Re: Objection to MP08_0244 MOD 1 Modification Request for Mixed Used Development at 23-37 Lindfield Avenue and 11 Havilah Lane, Lindfield

As a resident of Lindfield, I/we wish to lodge an objection against the proposed Modification of the subject development based on the following grounds:

ELEVATIONS

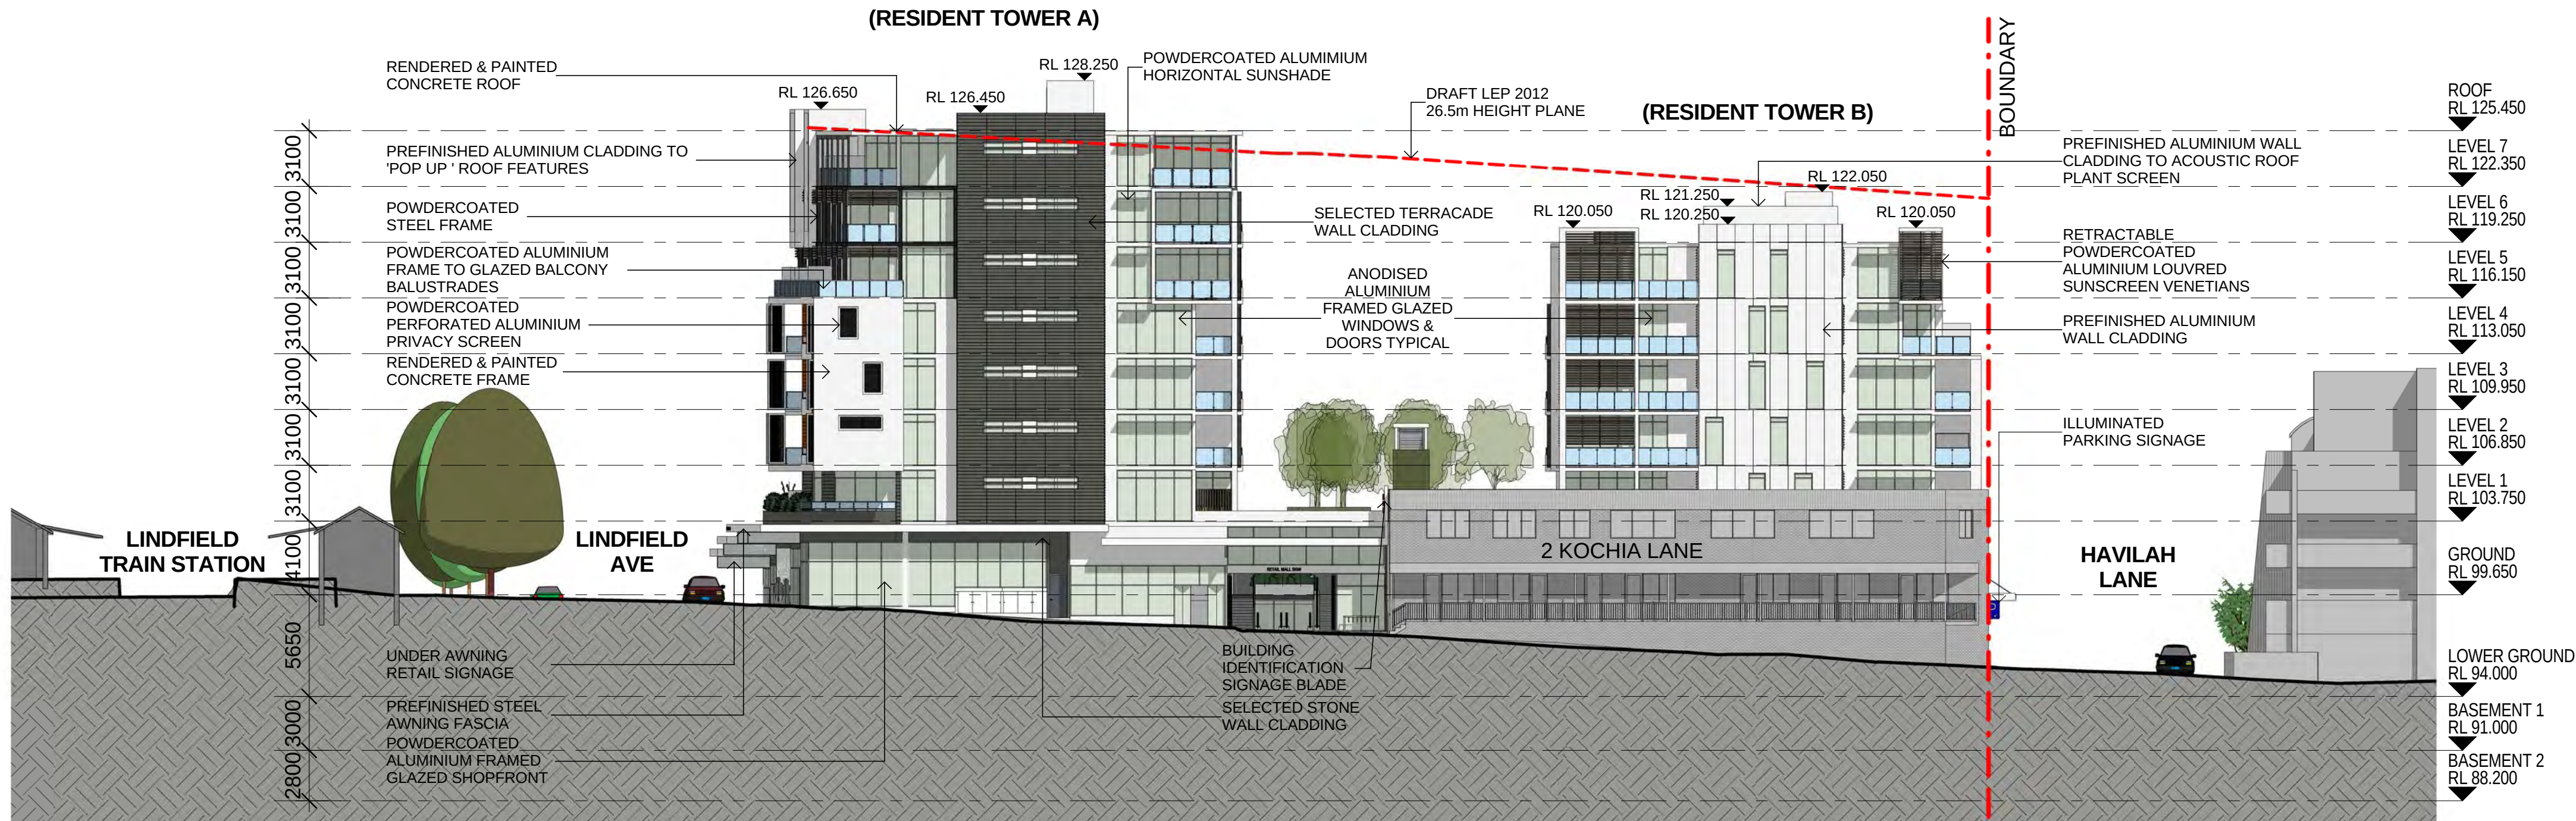
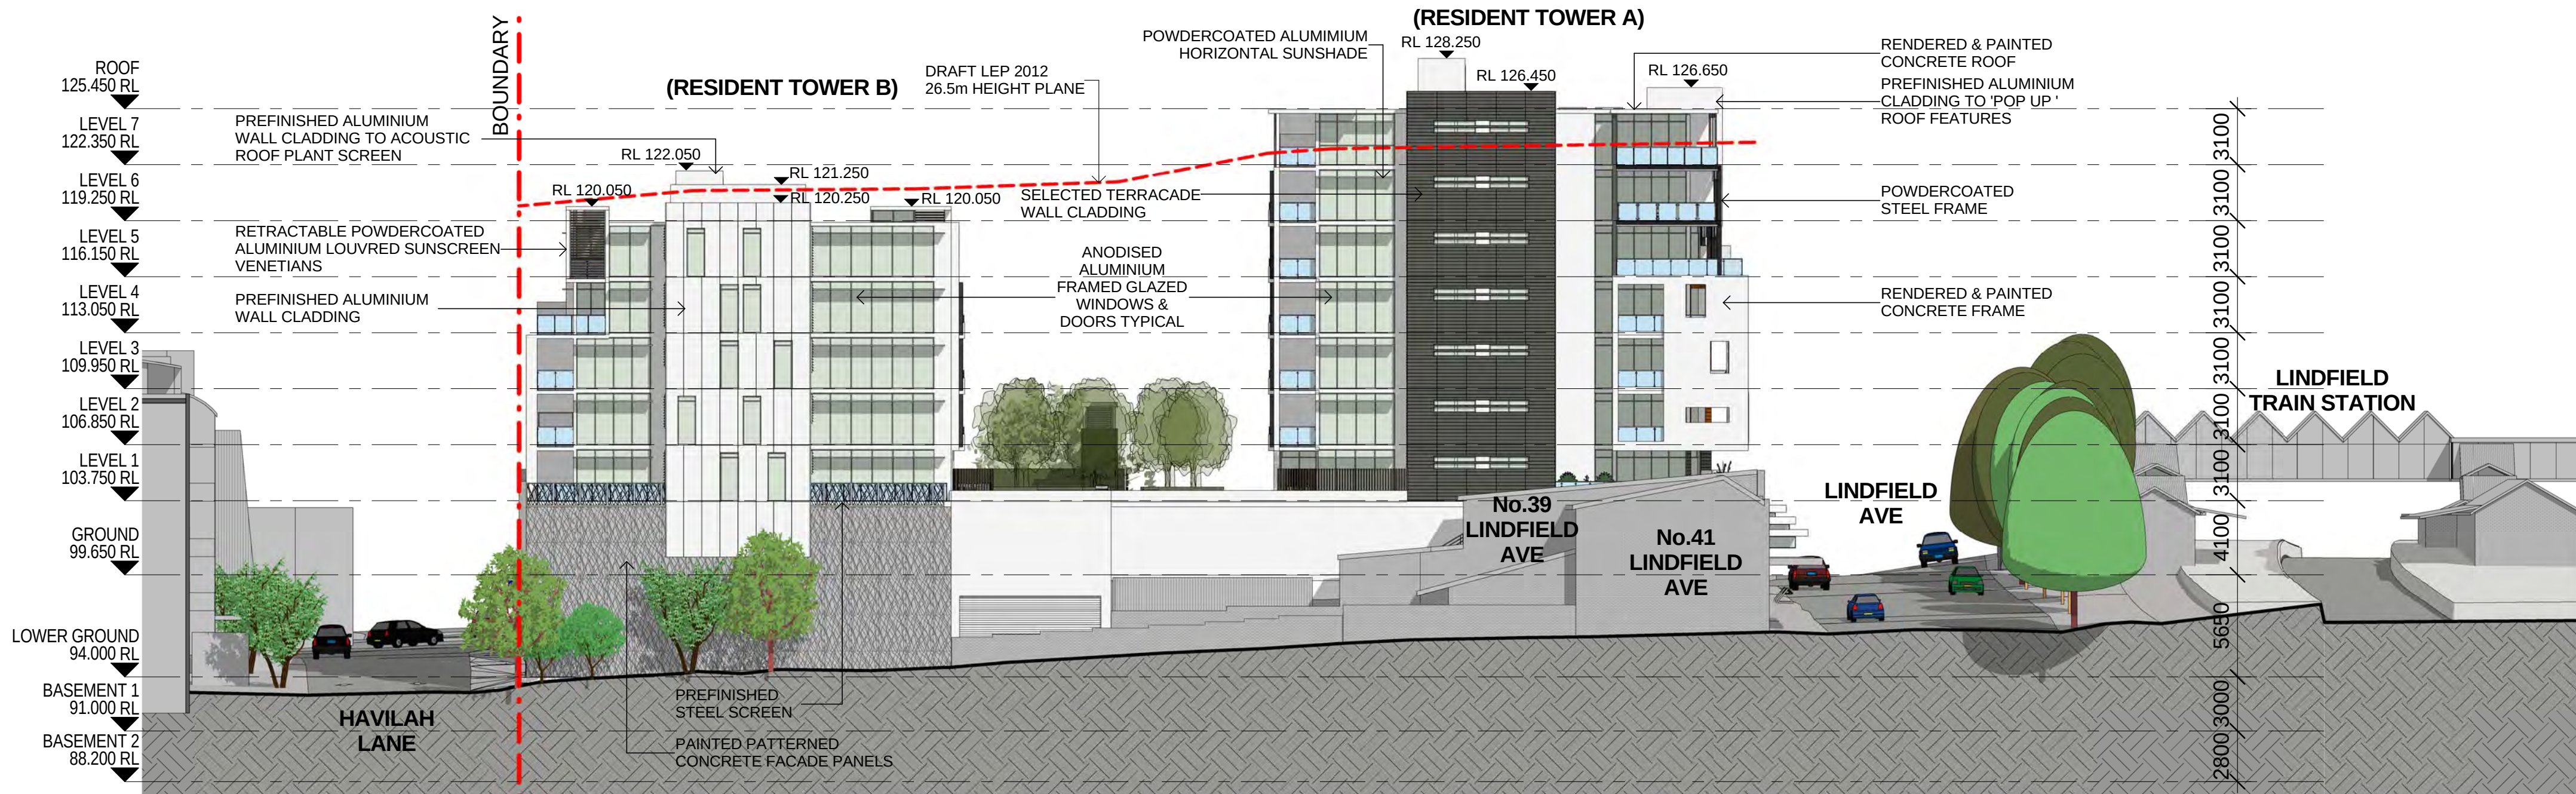
- The increase of an additional storey to both buildings: 8 storeys on Lindfield Avenue and 7 storeys on Havilah Lane creates excessive height and bulk and is out of character with the surrounding buildings, including the heritage listed adjacent building on Lindfield Avenue

- The additional storey (combined with less set back than the approved design) on Havilah Lane now creates privacy concerns for over 40 apartments in the adjacent 8 Havilah Lane, 8 Kochia Lane and 2-8 Milray Street residences
